From:
Sent: 11 May 2026 15:41
To: DC Admin
Subject: Planning application 2026/90930

Please find below comments regarding the proposed extension at 349 Whitehall Road, Wyke, BD12 9DP.

Existing Ground Floor Plan  
Scale 1:100@A1

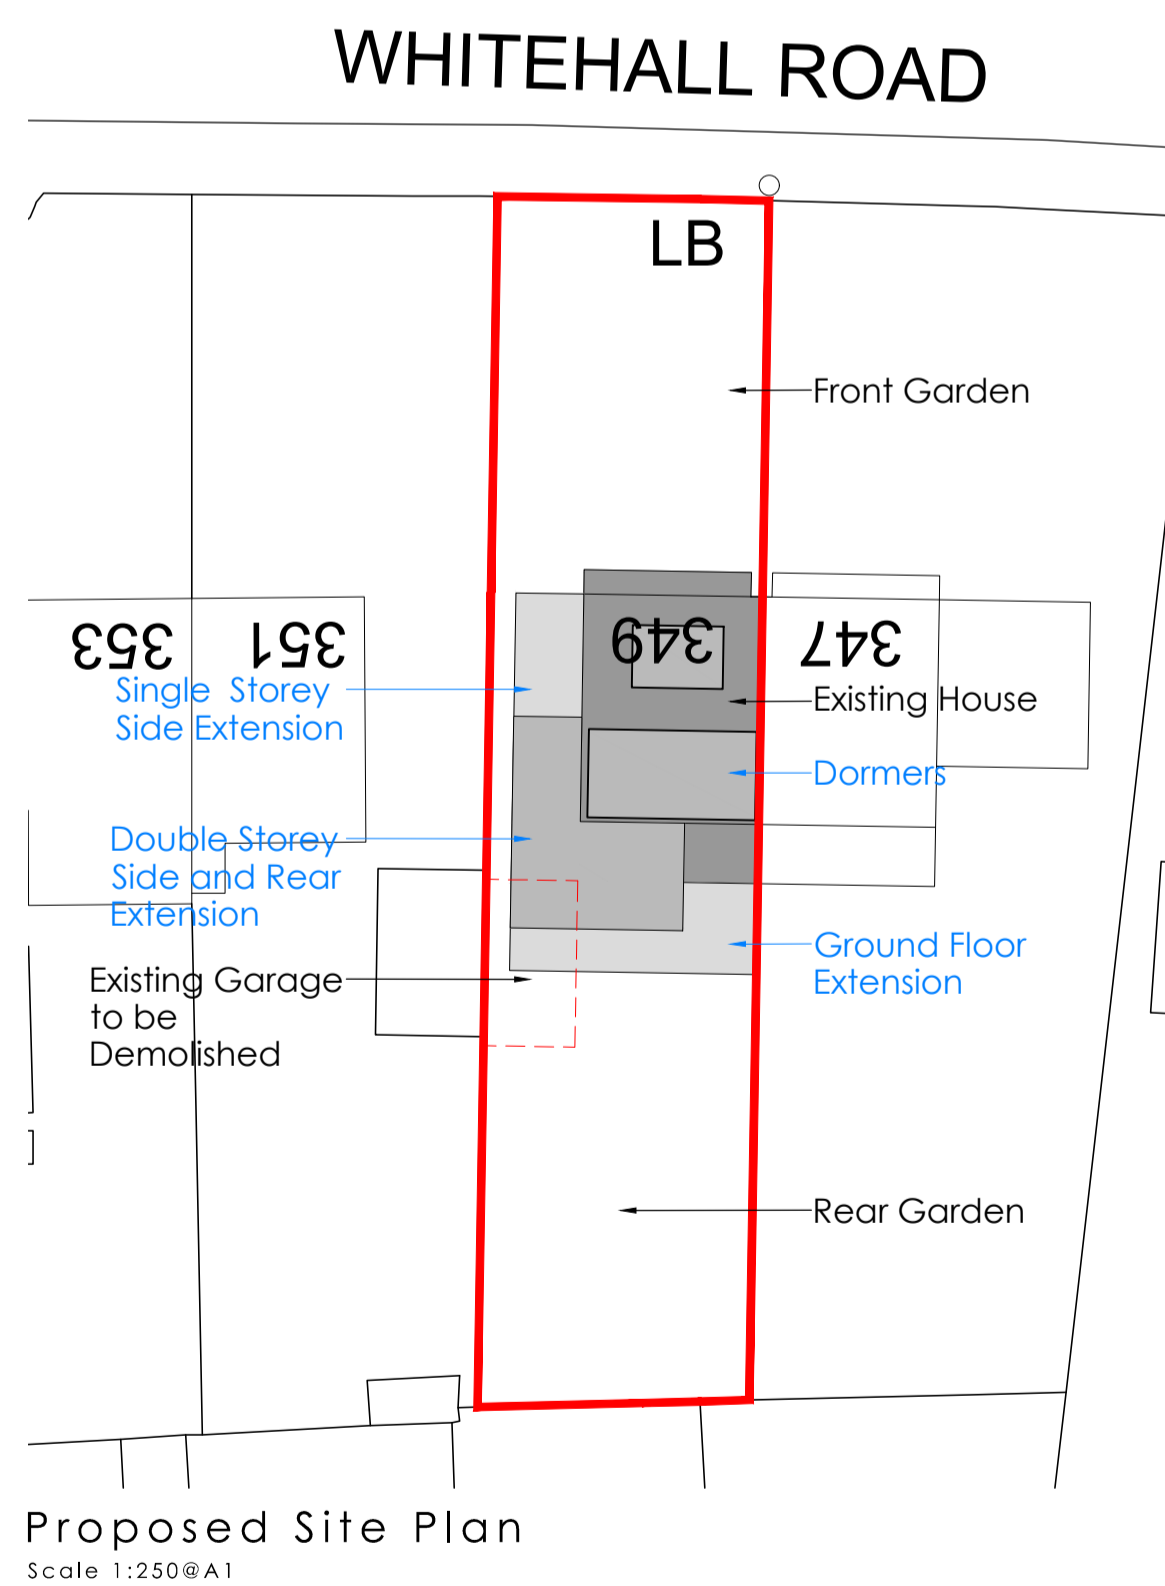
The number of bedrooms shown on the plans is a 4 possibly 5 bedroomed house (if the walk in wardrobes are used as bedrooms once completed). If the residents own several vehicles there is insufficient room on the drive to park these and again will impact the neighbours. Outside of 349 is a lamp post which makes it difficult to park on the road directly in front of this house, meaning the residents may park in front of the neighbours' houses obstructing the view of traffic when gaining access in and out. This will cause both frustration and be dangerous as we all need the ability to easily gain access in and out of our properties in a safe way. Whilst I appreciate you cannot legally stop people from parking directly outside of your property it will likely result in arguments. This is why the existing residents opened their driveway up to park the 2 vehicles they owned.

Client	N/A
Project	N/A
Address	349 Whitehall Road, Wyke, Bradford BD12 9DP
Title	Existing and Proposed Elevations

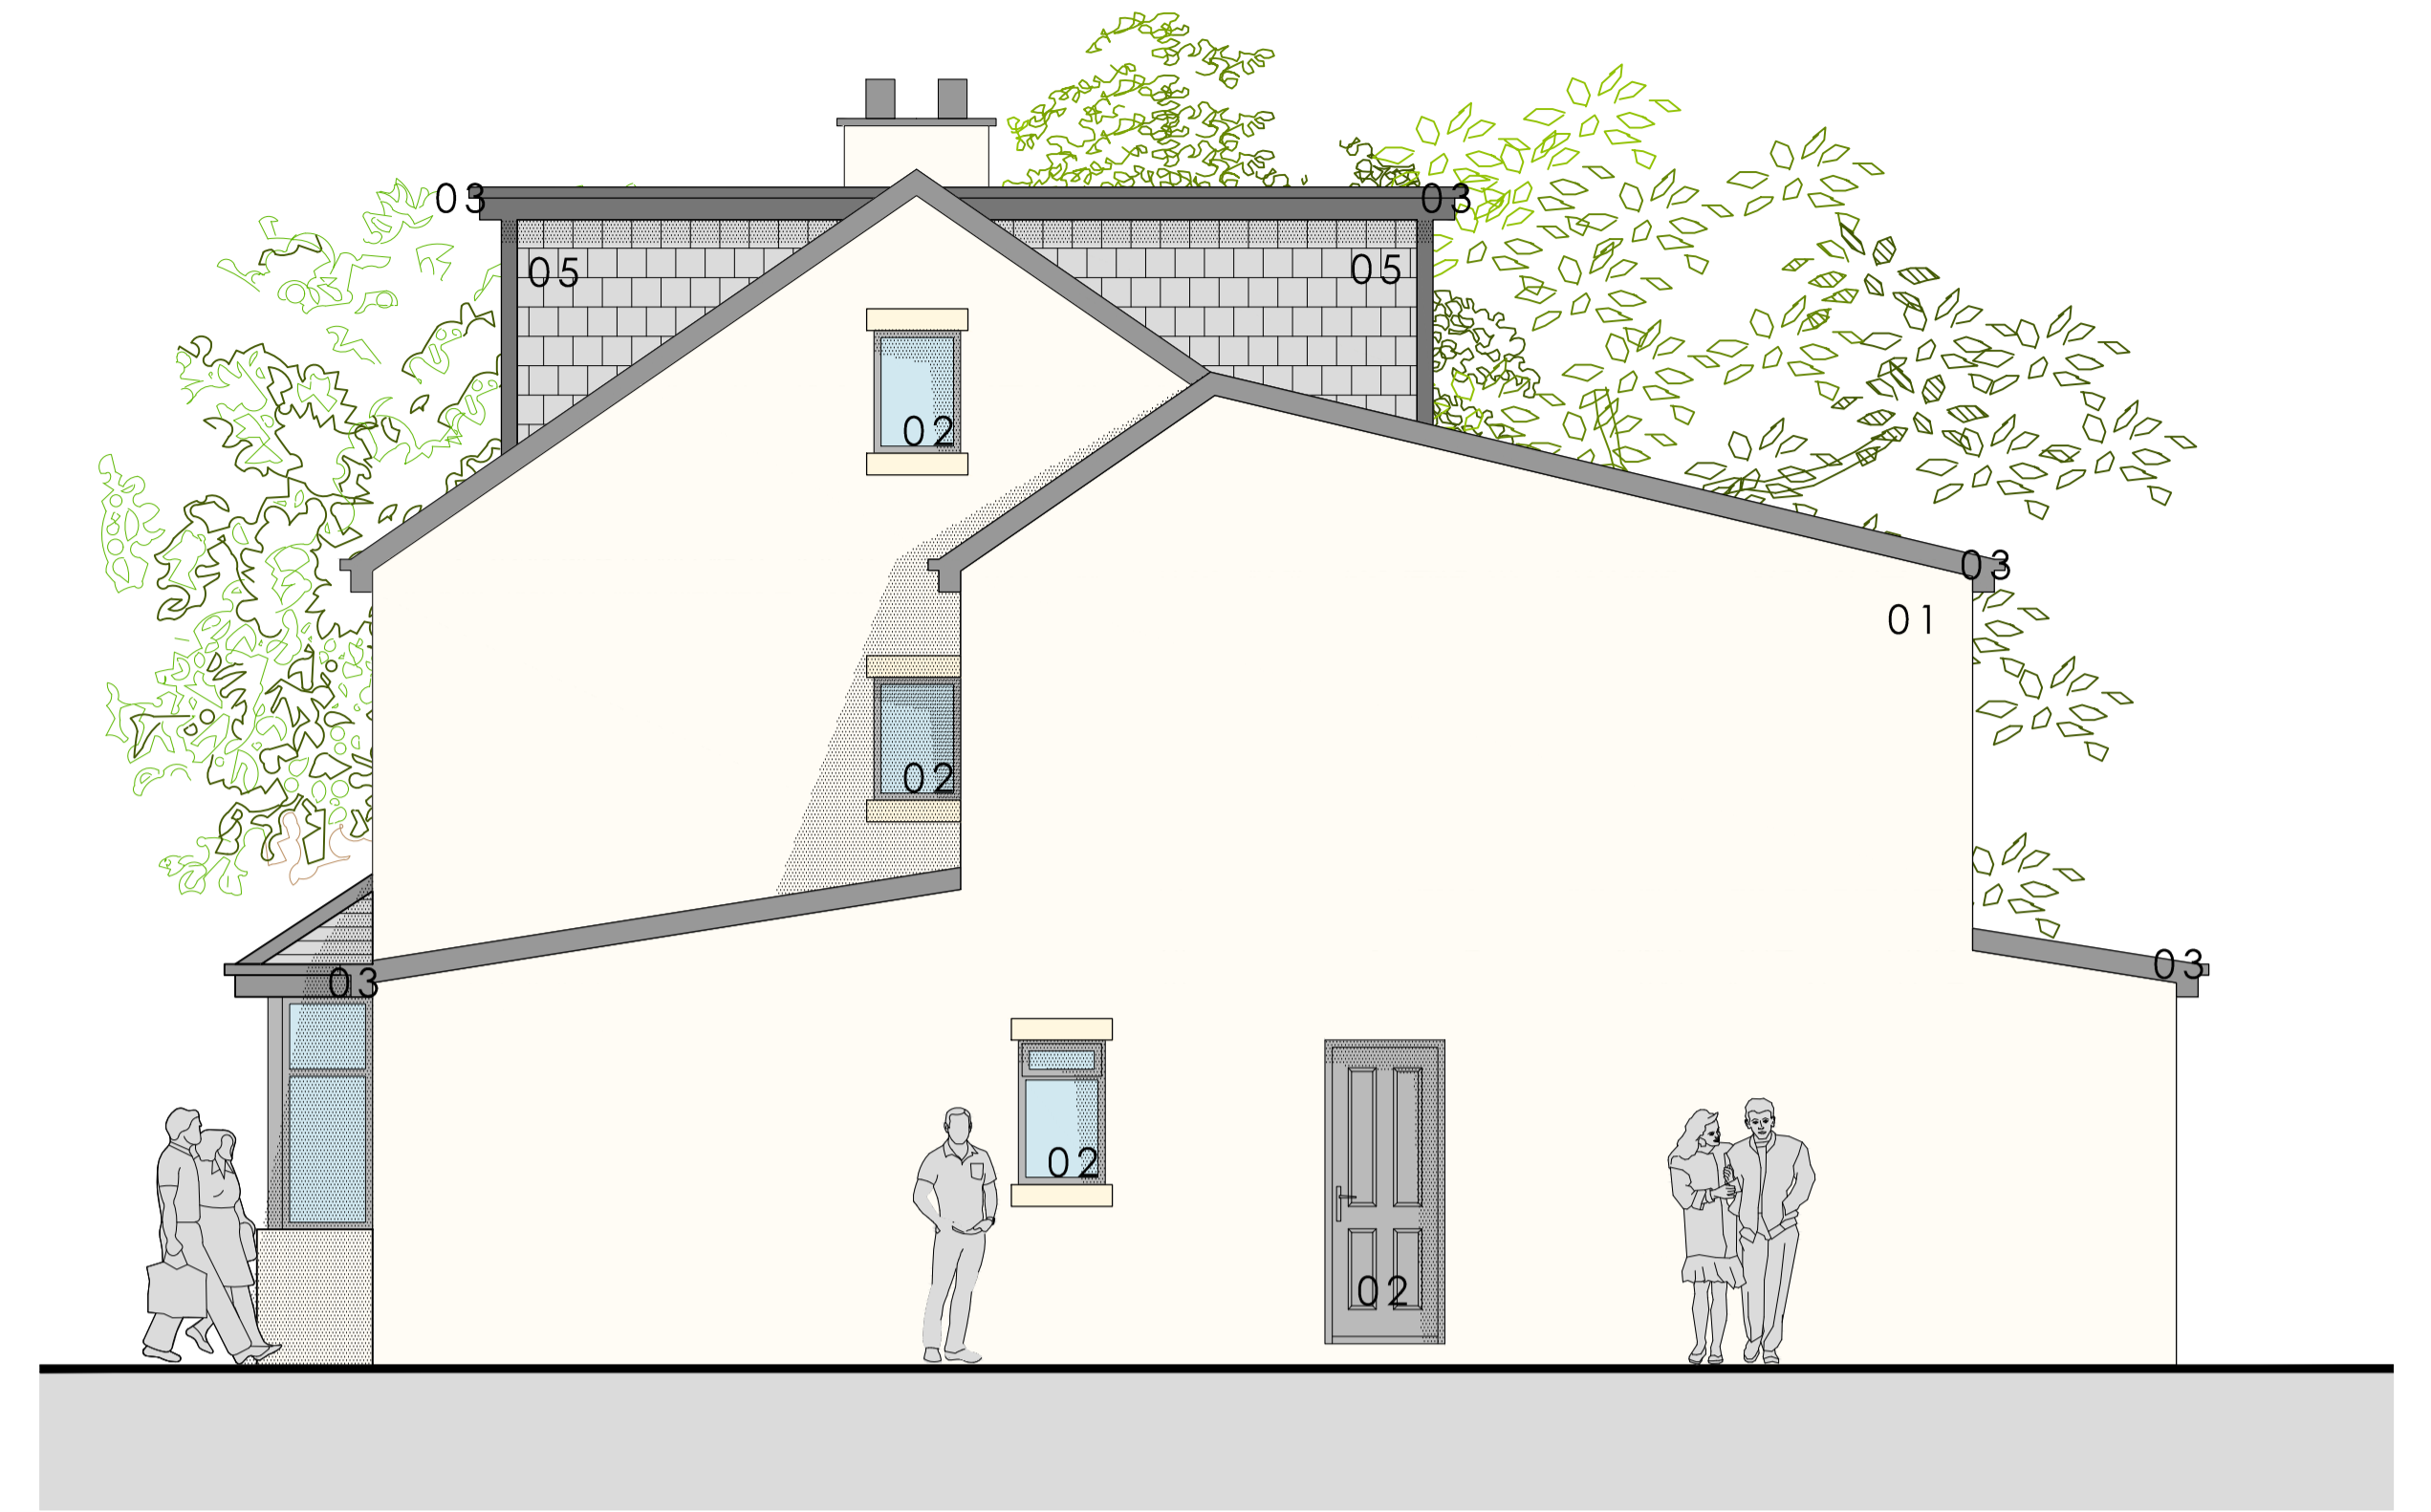
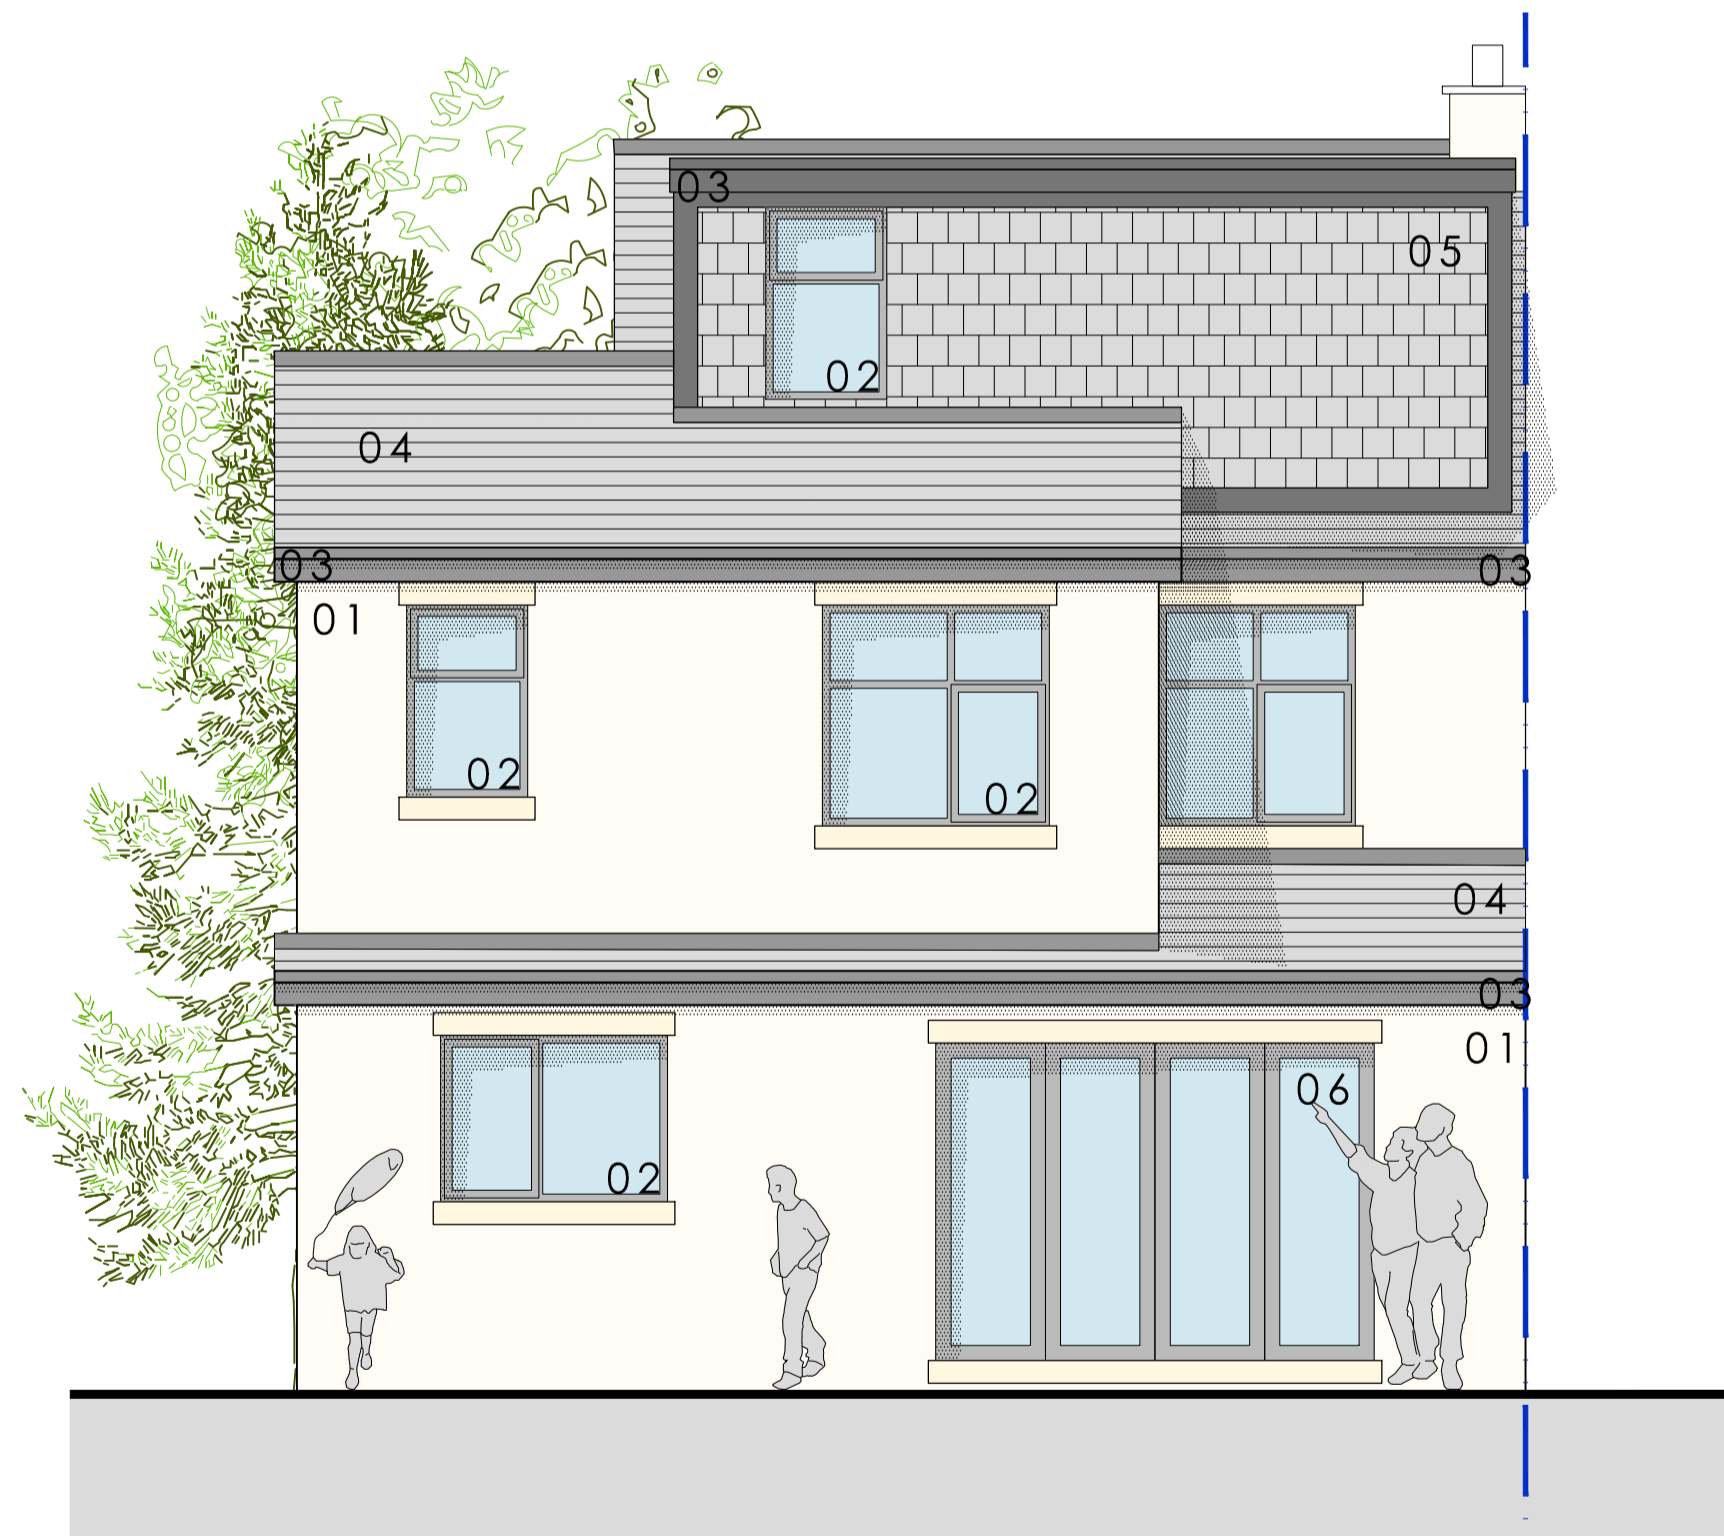
Having viewed the proposed plans for the extension, the property will double the existing property and is too large for the available space. With the Dorma extension it will tower over the existing properties which are small semidetached houses and not be in keeping with the area and look out of place and imposing. Also an invasion of privacy to the surrounding houses. These properties were built for small families.

Although I am not next door the extension is right up to the boundary and being double storey will block any direct sunlight making 351 very dark and if wishing to sell will have a negative effect on their property for proposed buyers.
